Wednesday 23 April 2025

Proposal: Erection of detached dwelling

Location: Land adjacent to 10 Douglas Street, Thornhill Lees, Dewsbury

Waterway: Calder & Hebble Navigation

10 DOUGLAS ST DEWSBURY CANAL SECTION 1:100 10DSD/201

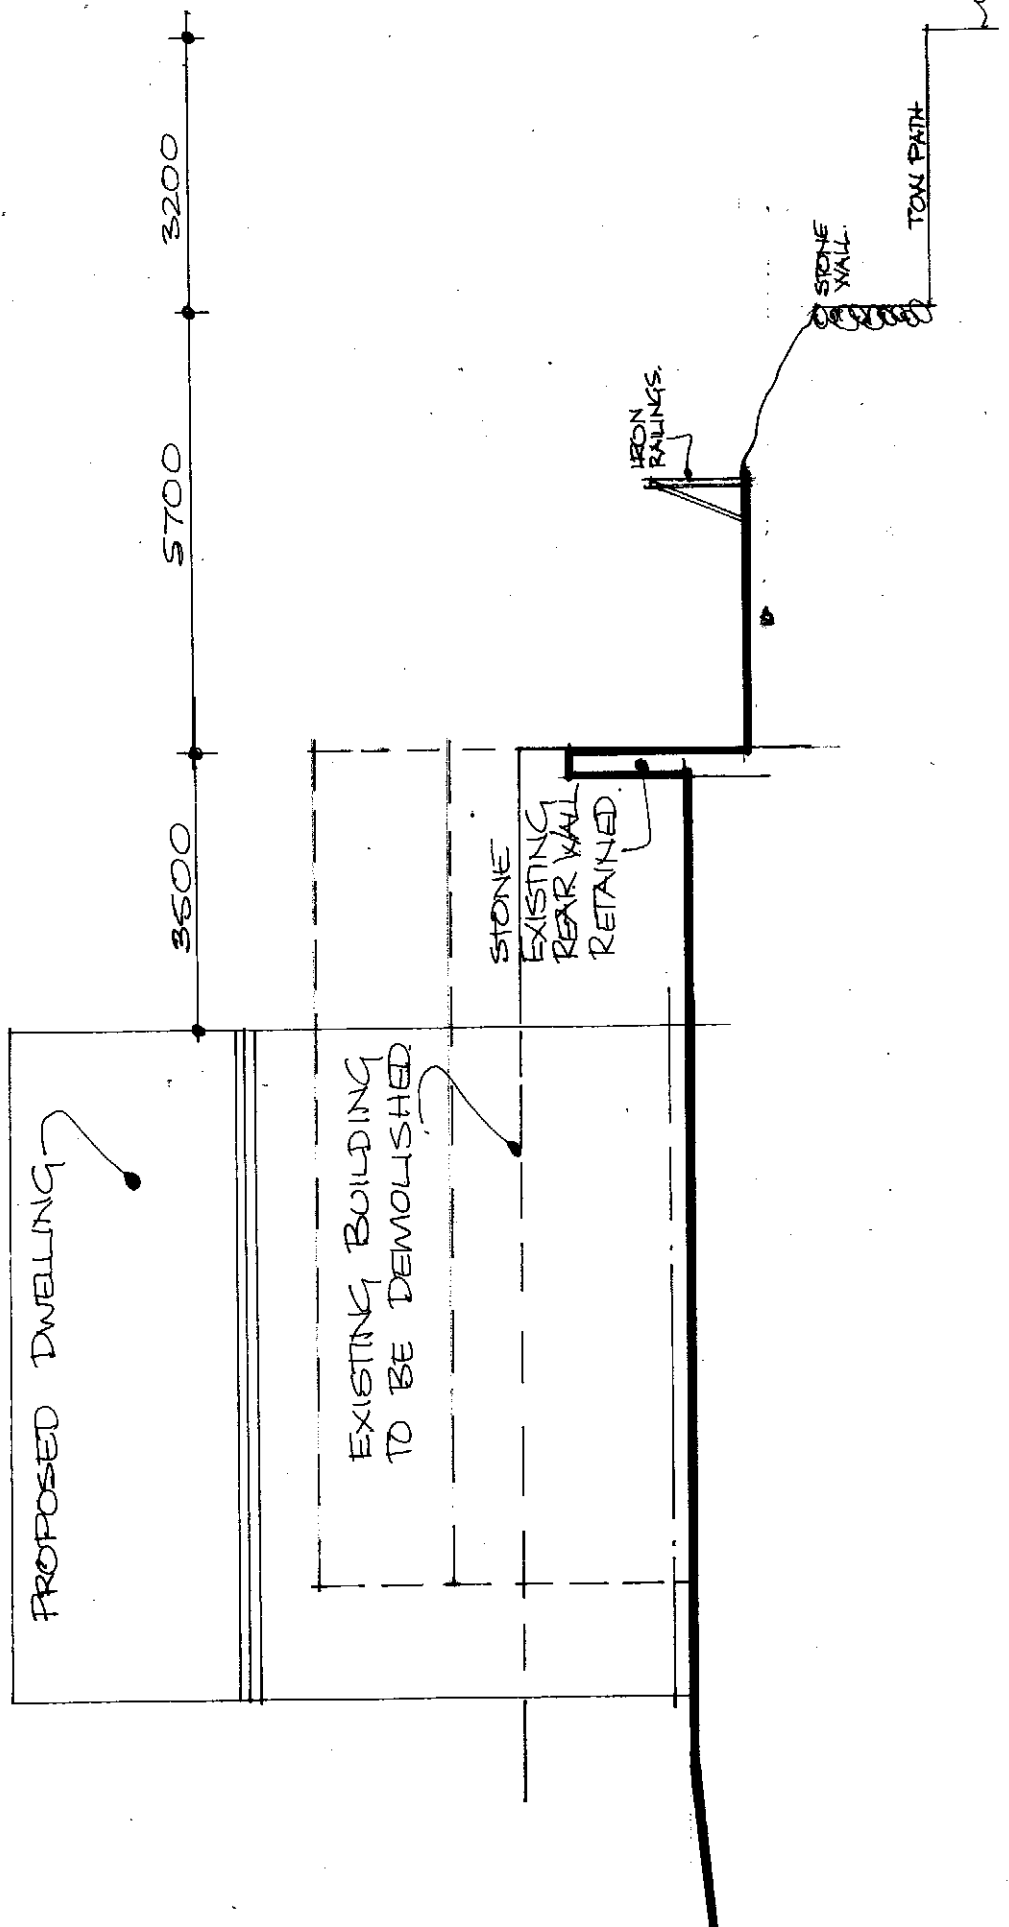
To avoid the risk of the exposure of the canal to dust or debris during development, we request that a Construction Management Plan should be used to inform demolition and construction on site. This should detail measures to limit dust, and to manage the risk of runoff from exposed soils on site towards the canal (the use of silt traps for example could be used). **Full details could be reserved through the use of appropriately worded pre-commencement condition(s).** This is pertinent for this site as the canal is at a lower elevation to the site.

We request that full surface and foul water drainage details are provided to ensure that no unmanaged discharge to the canal would occur. This is necessary to prevent the formation of a pollution pathway or inadvertent erosion to the canal embankment slope.

B 30/4/25 BOUNDARY DETAILS ADDED.
A 18/2/25 BEDROOMS REDUCED
PR ELEVATIONS 100SD/03

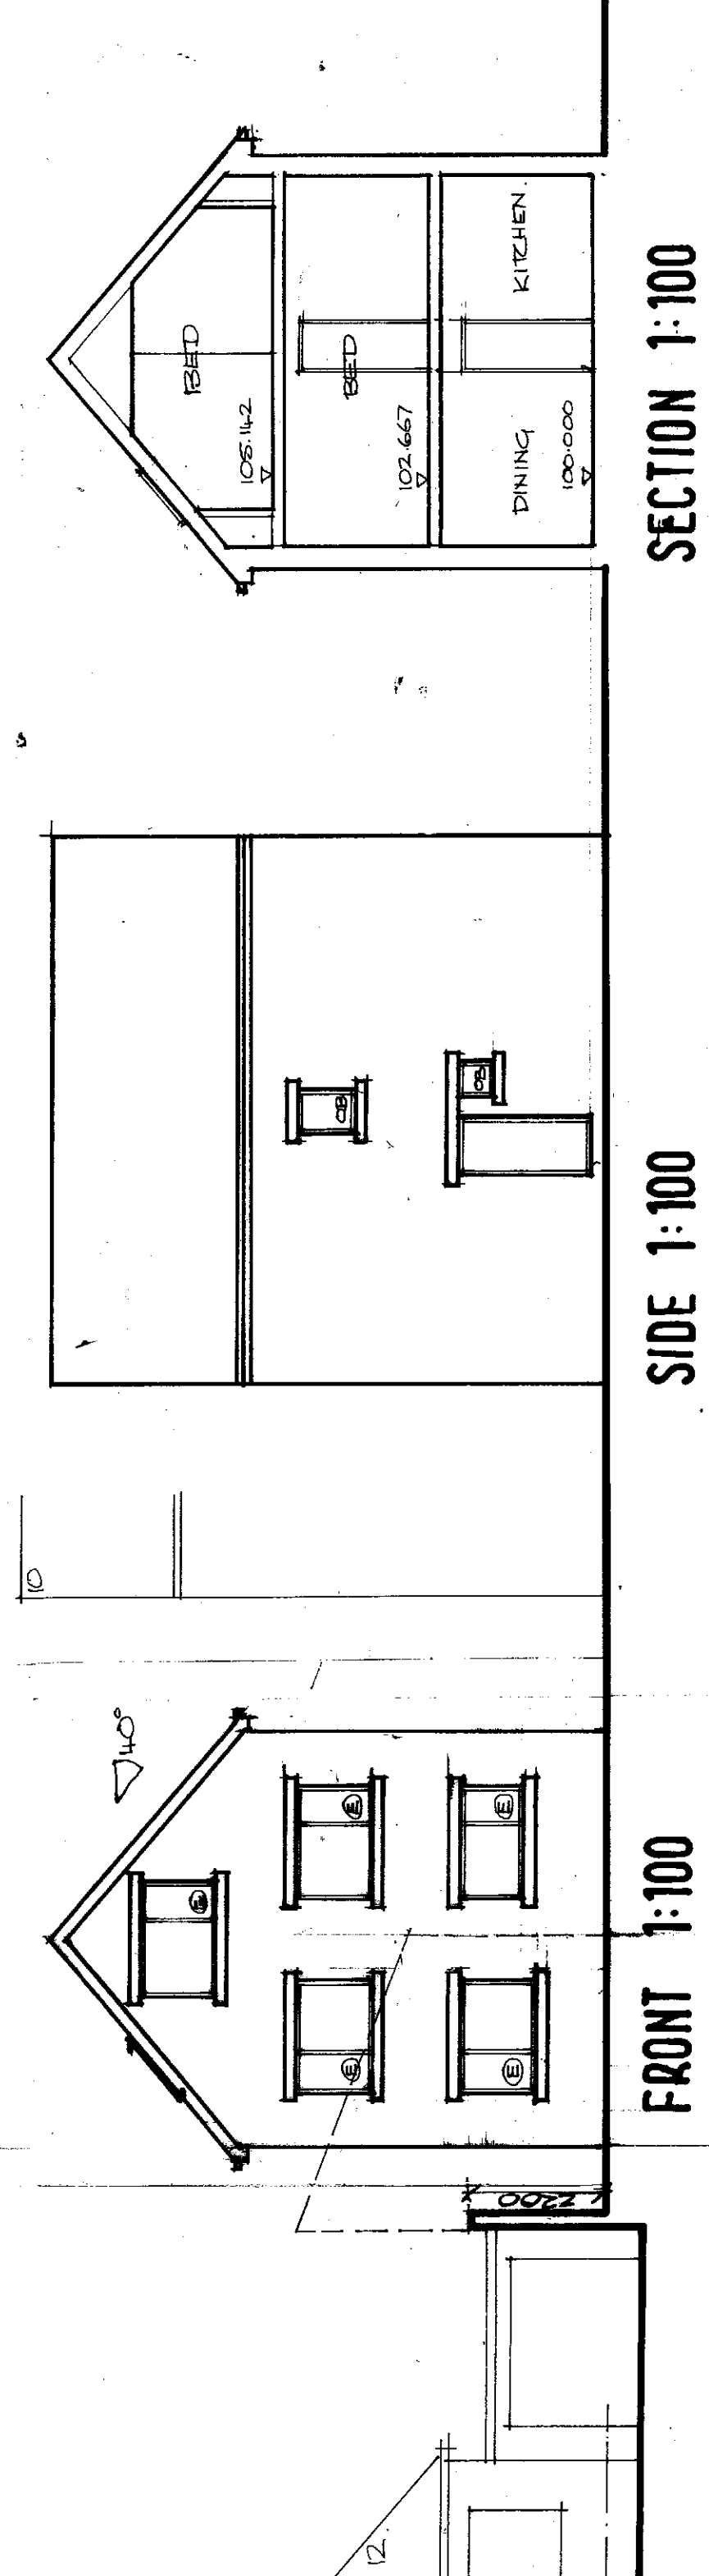
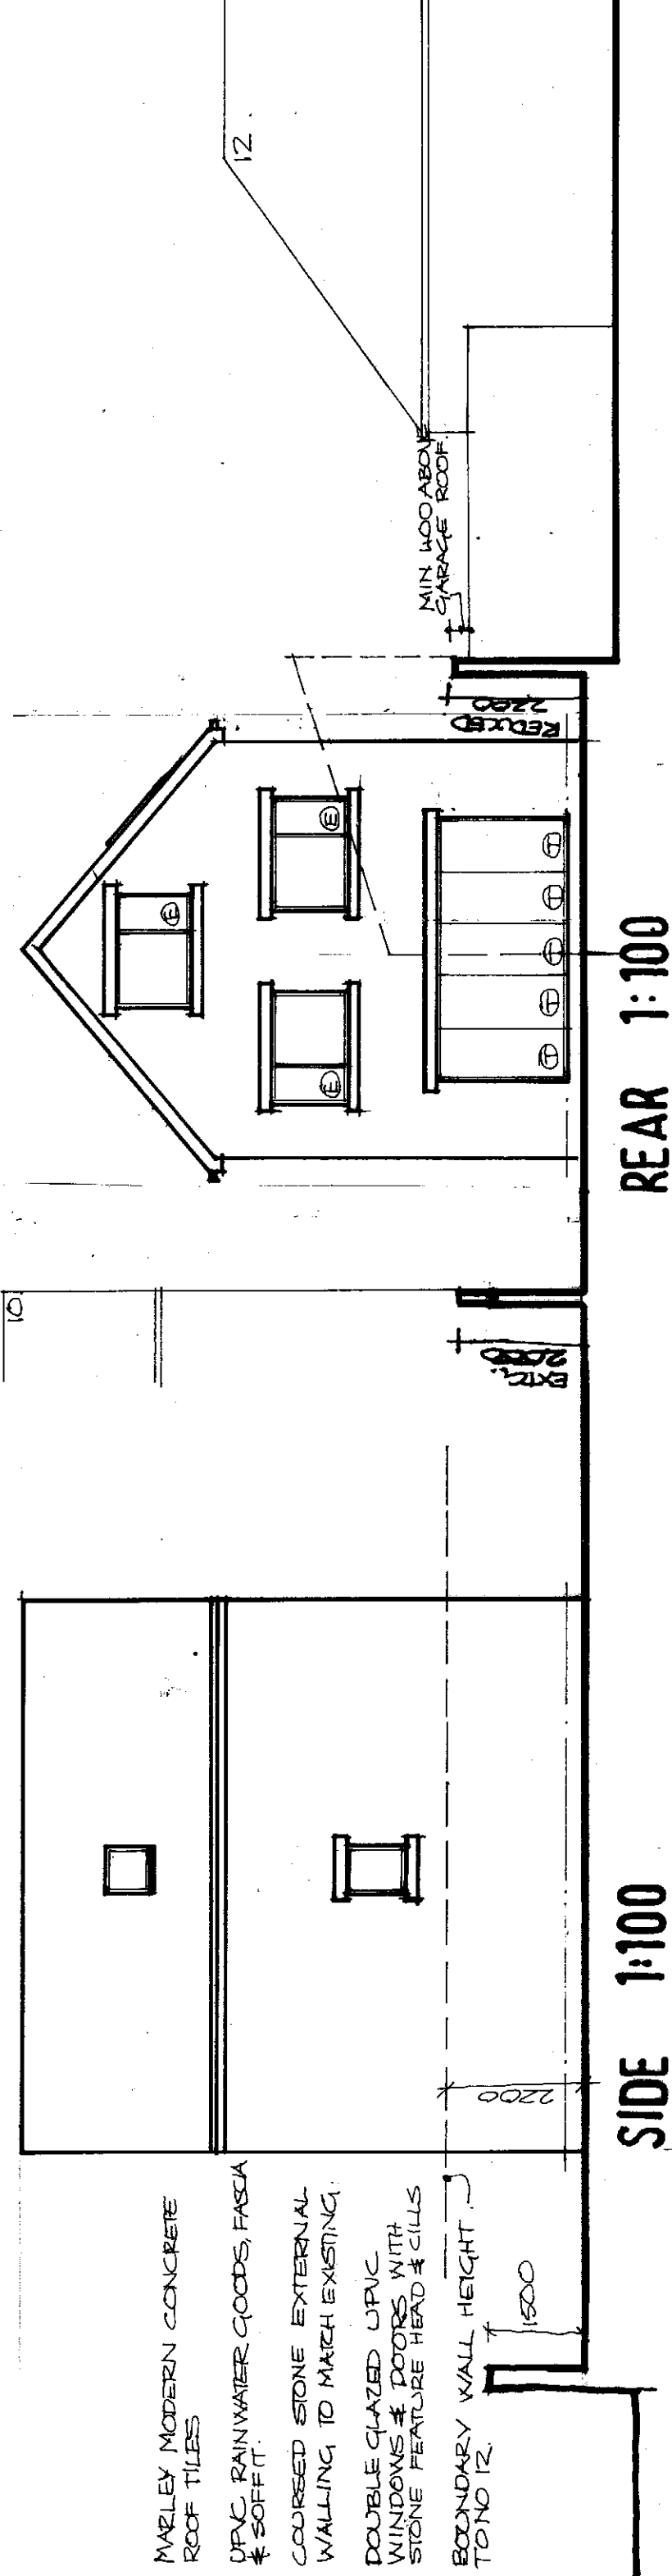
We request that full details of the rear boundary treatment to the site should be provided so as to ensure that this will be of appropriate quality and will not detract from the character and appearance of the canal corridor. The retention of the existing railings or formation of a landscape buffer would tie in with the waterway environment. Solid tall fences would give a sense of enclosure to the canal, which could result in an overbearing impact to the canal and should be avoided.

Boundary details could be reserved through the use of appropriately worded condition(s). This would help ensure compliance with the aims of LP32 from the adopted Local Plan.
